From: alan.story@hertfordshire.gov.uk
Sent: 07 July 2015 09:06
To: Planning
Subject: Planning application S6/2015/1061/MA - Plot 6000 Hatfield Business Park

Response to Planning application from Hertfordshire County Council (T and CP GDP Order 2015)

District ref: S6/2015/1061/MA
HCC ref: WH/161/2015
HCC received: 18/06/2015
Area manager: James Dale
Case officer: Alan Story

Erection of a private healthcare facility (use Class C2), to include car/cycle parking, boundary treatment, landscaping, lighting and access

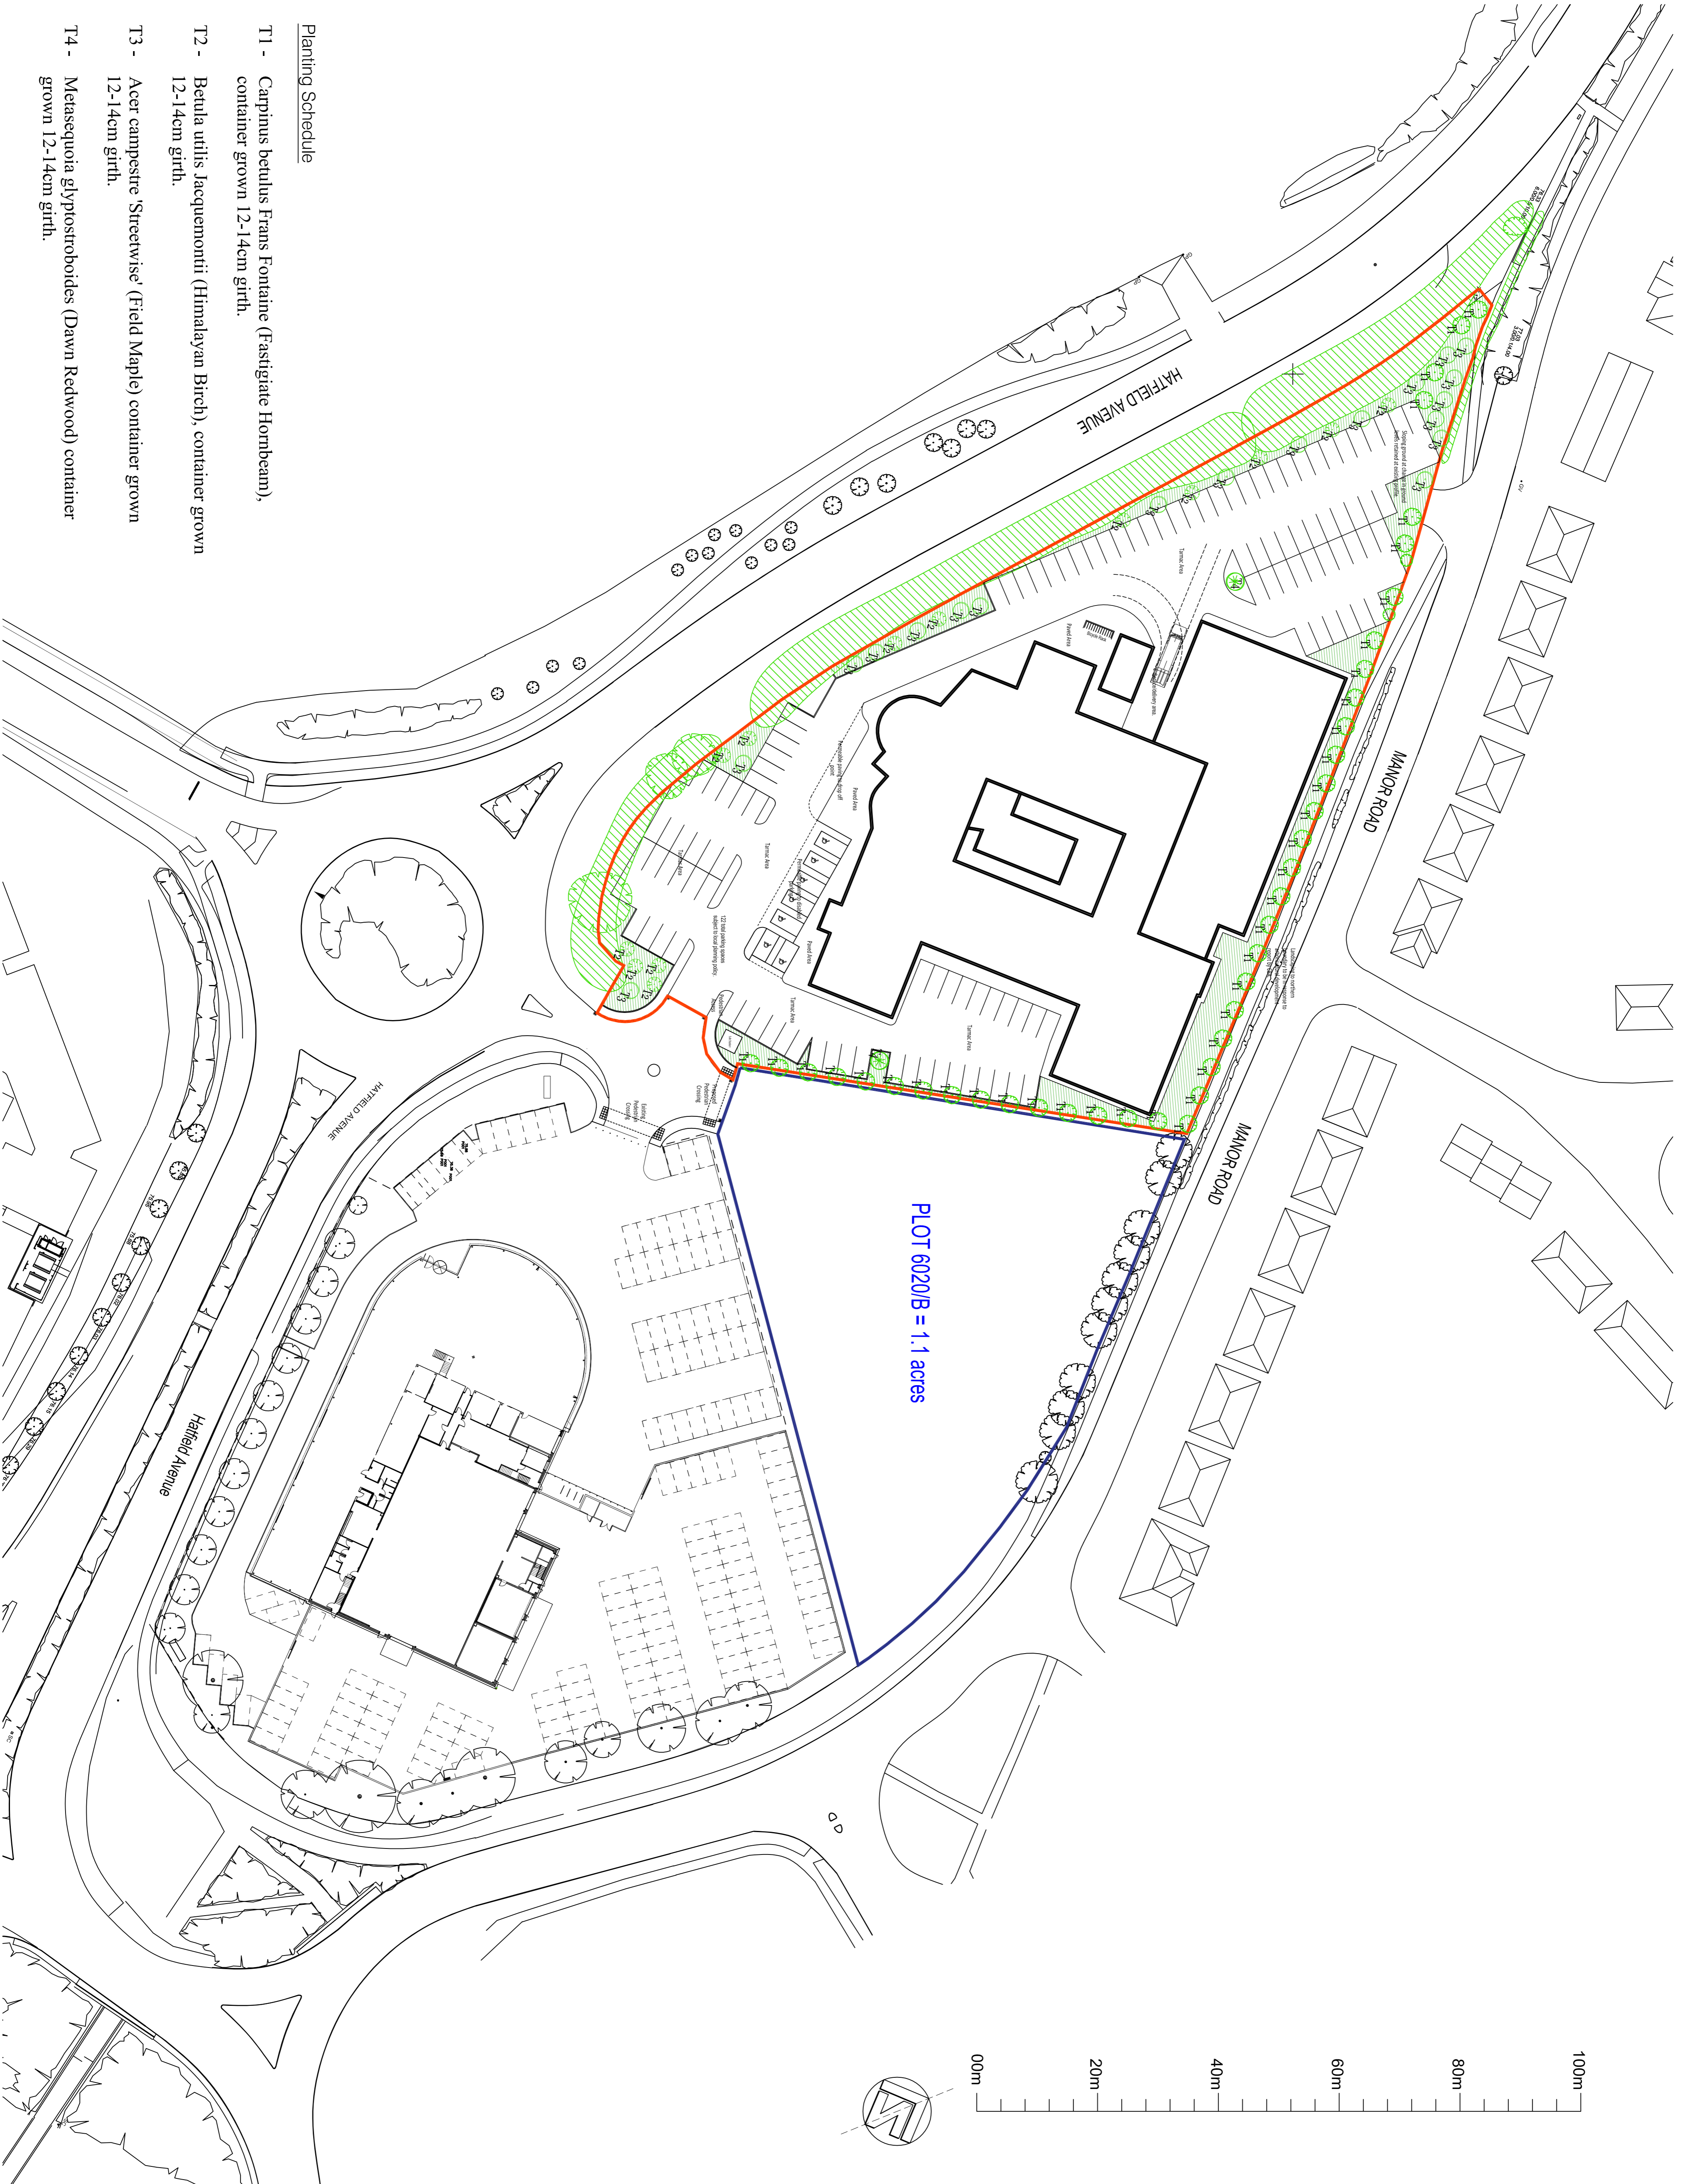
The parking appears to be suitably provided, with spaces to a minimum of 2.4m x 4.8m, however I would highlight that spaces in proximity to the route between parking at front and rear, i.e. eastern boundary, close to the cycle parking facilities adjacent to the stretch of internal route with no parking, appear to only enjoy 5m clear behind (affecting approx. 7 spaces). This would likely result in significant difficulties in entering the spaces.

MfS identifies that a minimum 6m depth is required where bays are 2.4m in width. It is recognised that reductions on this 6m are permissible, where a degree of forward and back manoeuvring is permitted, to access the space, and therefore given this location reasonable to accept, but whether approx. 5m is sufficient should be tested through swept path. Alternatively opportunities to orientate parking in echelon arrangement, or widening carriageway at these points be explored.

I would observe a discrepancy between the TA and application form. The TA (and plans, 1005 PL 202 Rev B) identify 122 parking spaces, however section 10 of the application form suggests only 115 parking spaces to be provided.
